From: Juan Baeza
Sent: 19 January 2018 13:42
To: Planning.Responses
Cc: Amanda Scholes
Subject: WA/78/17/DOC

From: Brendan Haworth [REDACTED]
Sent: 19 January 2018 13:26
To: Paul Cann
Cc: 'Andrew Davey'; 'Mark Willis'; Des McCall; Jack Dexter; Juan Baeza; 'Daphne Hobbs-Green'
Subject: RE: Walberton

Subject: RE: Walberton

Project: Red Cottage, West Sussex
Drawing No.: 536/501
Drawing Title: Typical Soakaway Section A-A
By: JD
Date: November 17

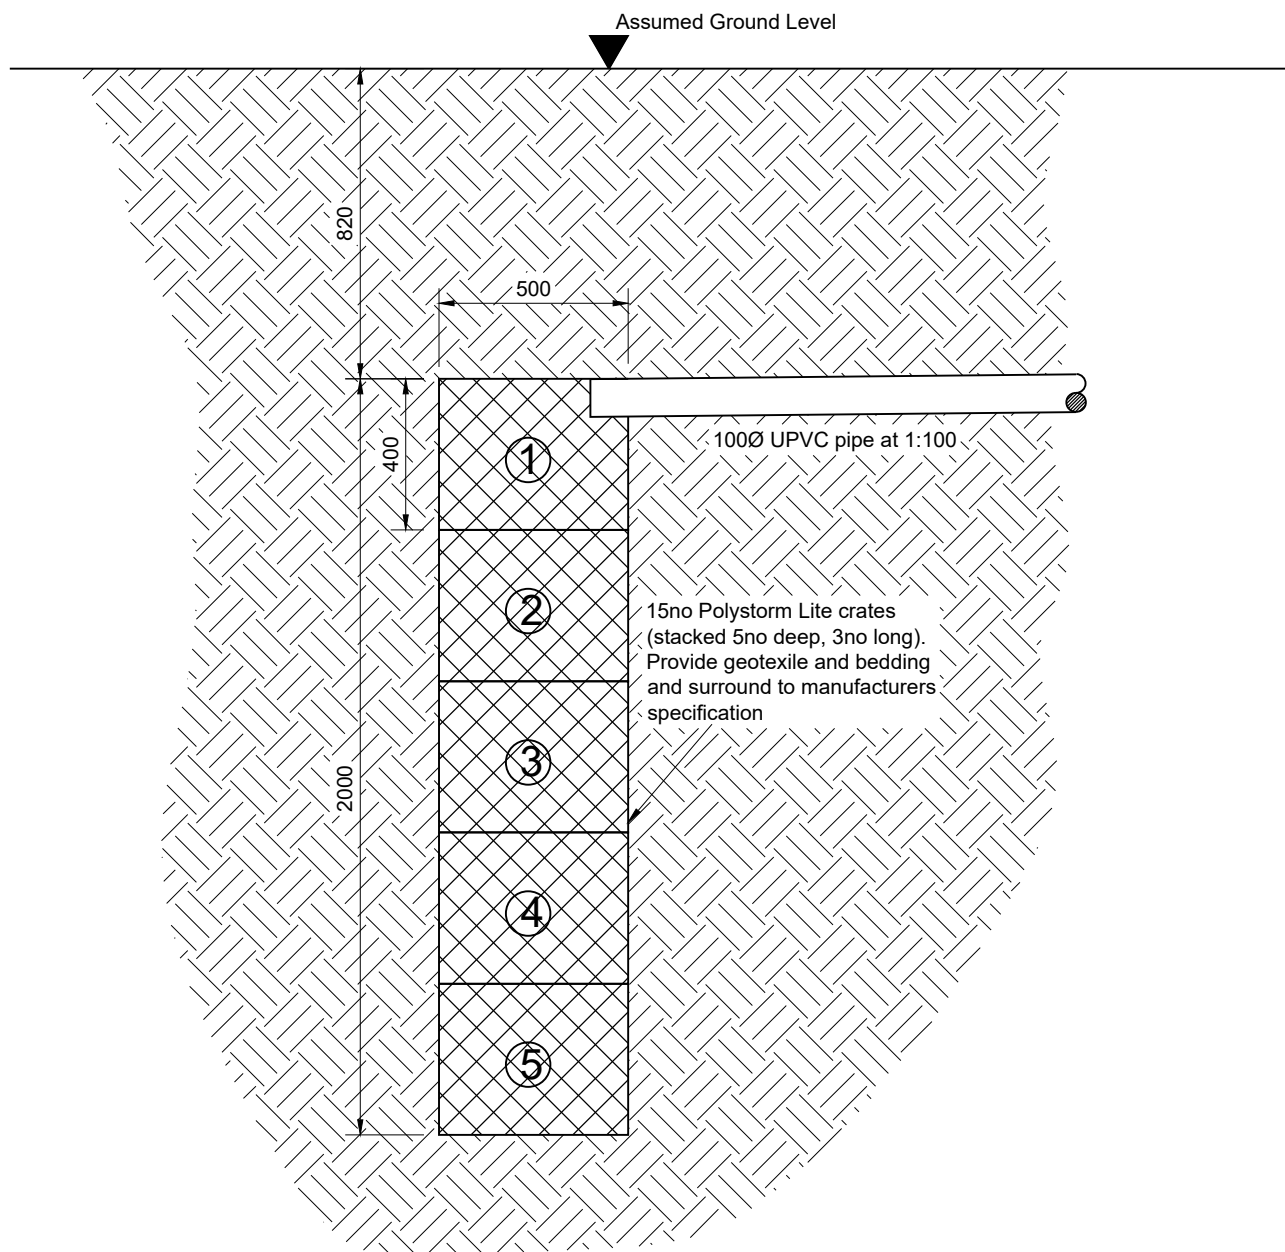
1. Please provide all the readings associated with the 13 minute percolation test ie. water level readings from 0 mins to 13mins, so the rate can be checked.
2. The storage calcs show a minimum soakaway depth of 1.944m being required. How can this be achieved based upon the design requirements. ie. soakaway base must not extend more than 2m below ground level and you also need to achieve adequate cover to the crates for protection.
3. Please show manhole cover/invert levels, including pipe invert at connection to soakaway.
4. Specify base level of soakaway ie. a level max. 2m below ground level.
5. Provide construction detail/section of soakaway (to include permeable geotextile wrapping).
6. Manhole SW4 is to be a catchpit (provide construction detail).
7. How is the driveway being drained? Provide full details/calculations.

Attached is our amended drawing and soakaway calculation show the soakaway size and position using the infiltration test results above.

| Drawing No.:   | 536/500C                                              |

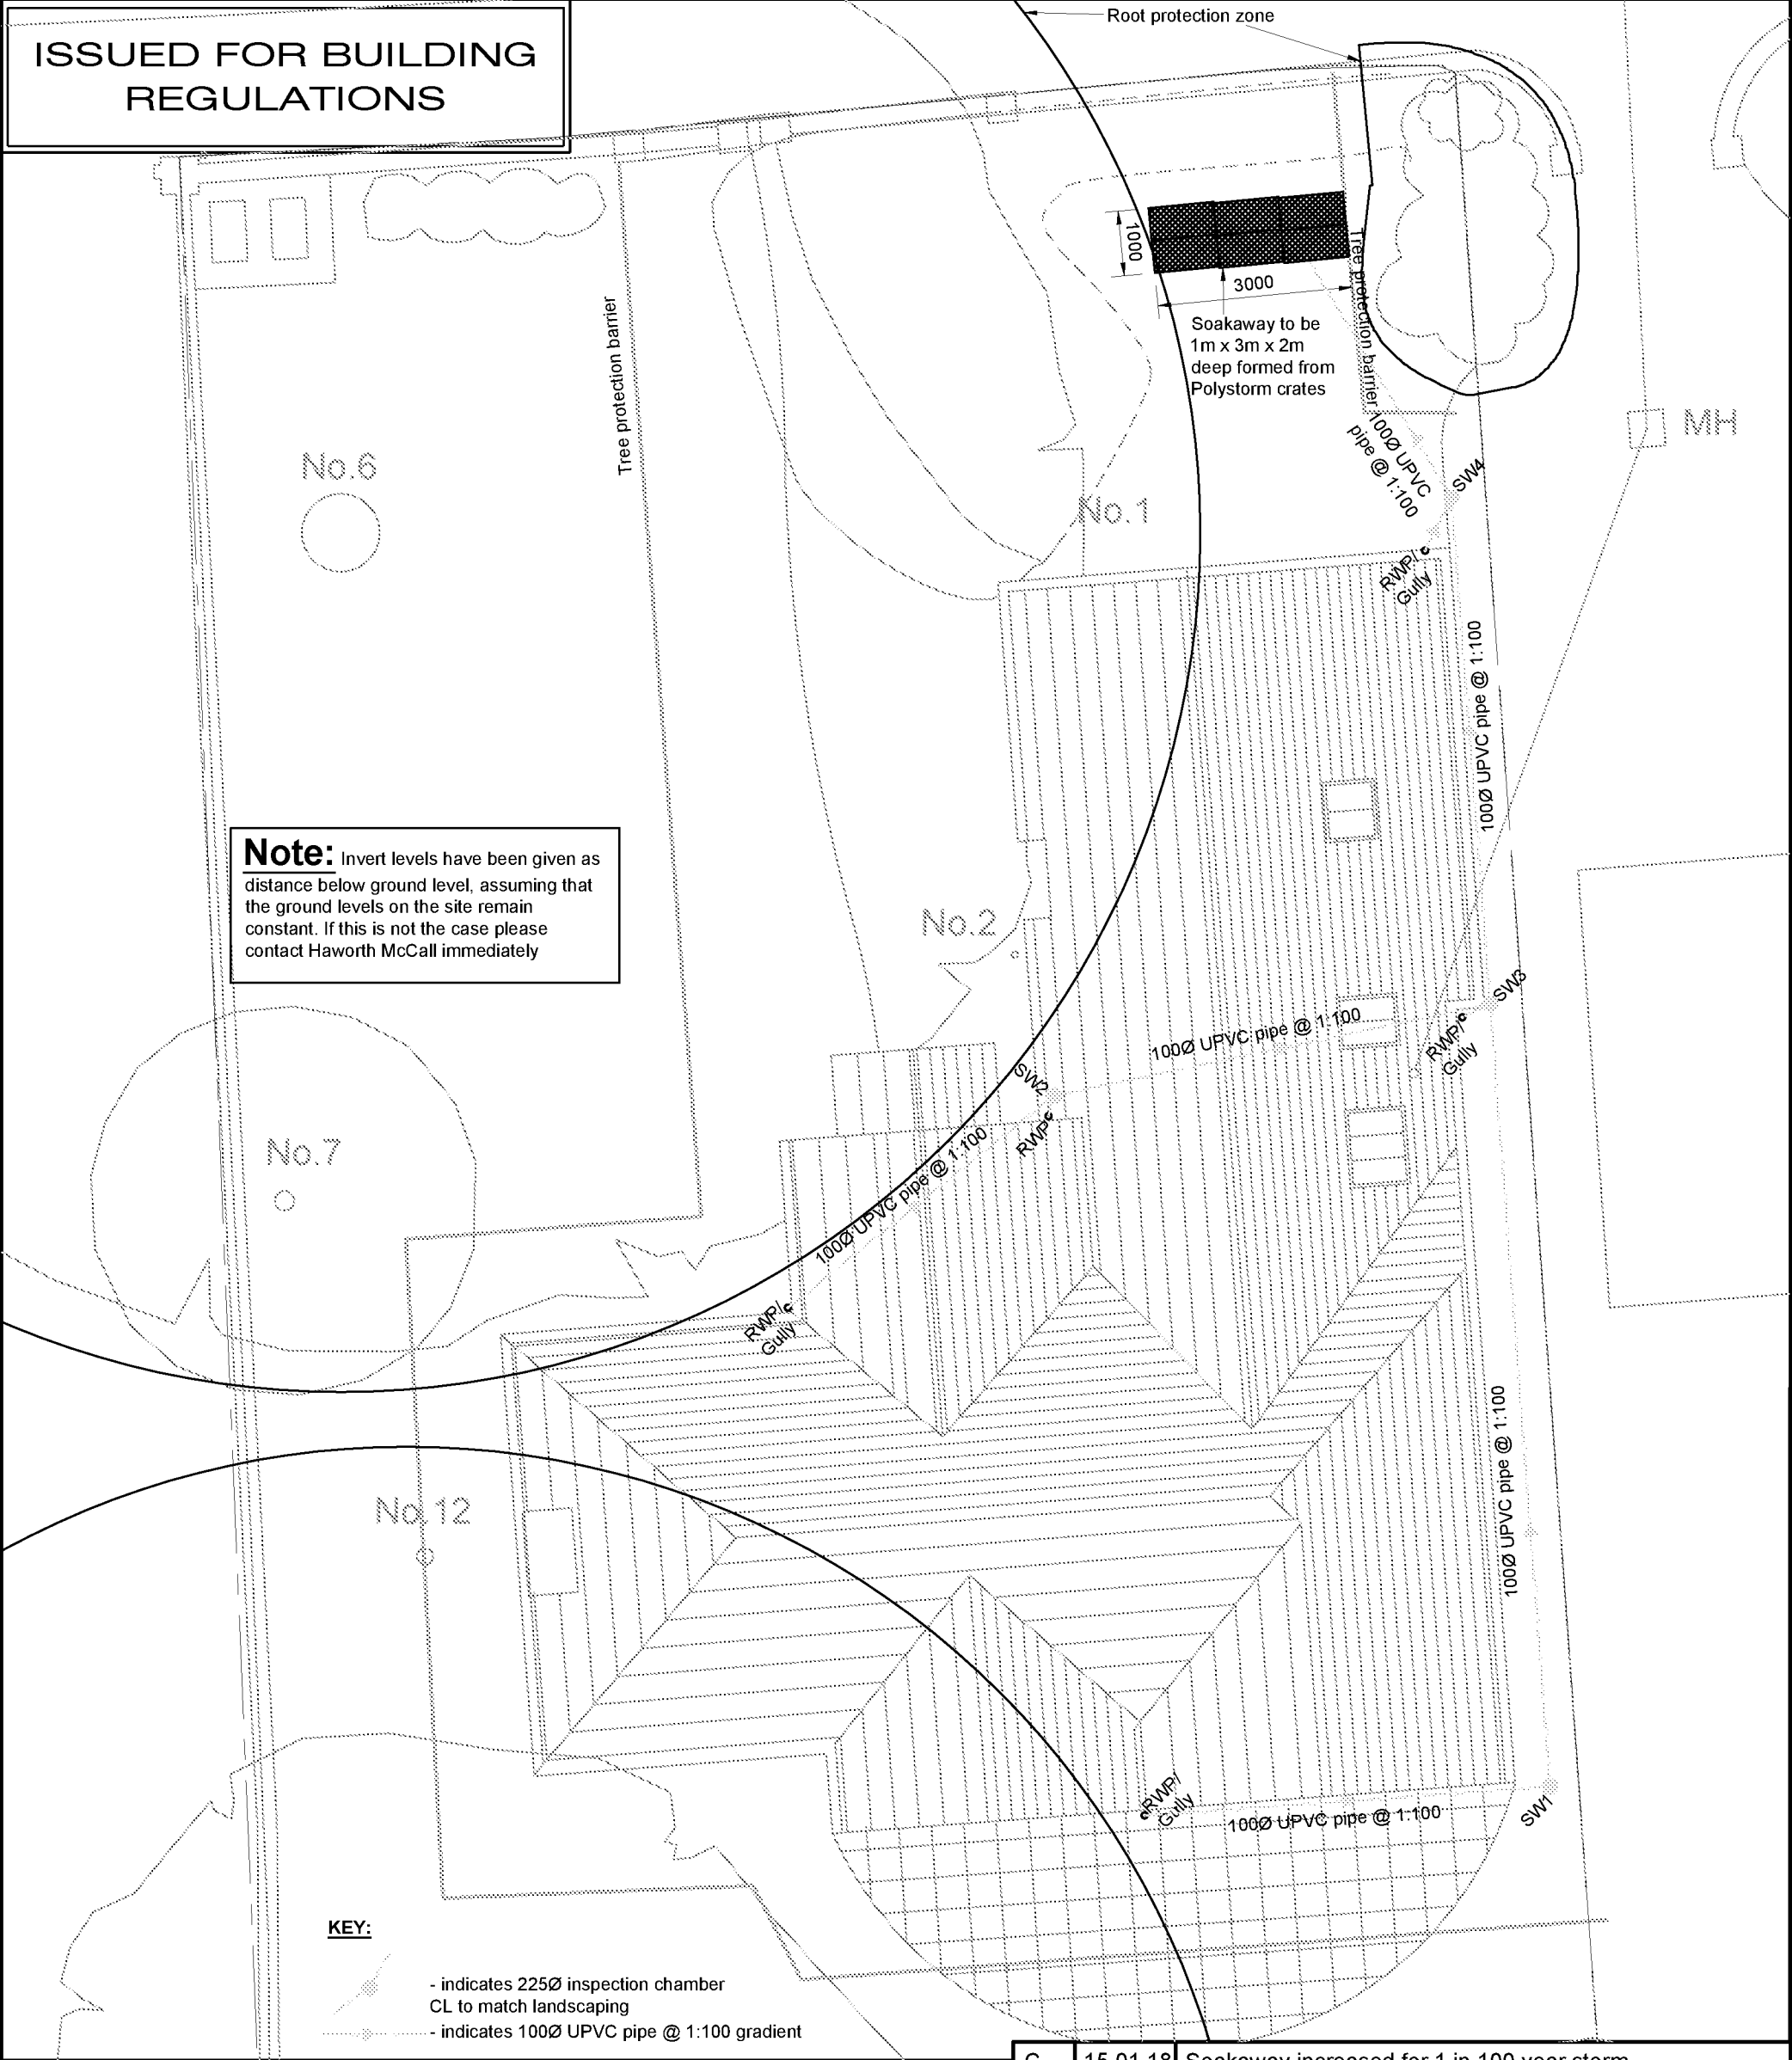
I look forward to receiving your design drawings (layout and construction details). Please note that the depth from ground level to the base of the soakaway must not exceed the depth of your trial hole.

Obviously the proposed formation level for the soakaways should not extend any deeper than your trial holes.

On point 7 of your e-mail, it has been confirmed by the applicant that all the hard landscaping areas will be permeable and therefore will not contribute to the soakaway calculation.
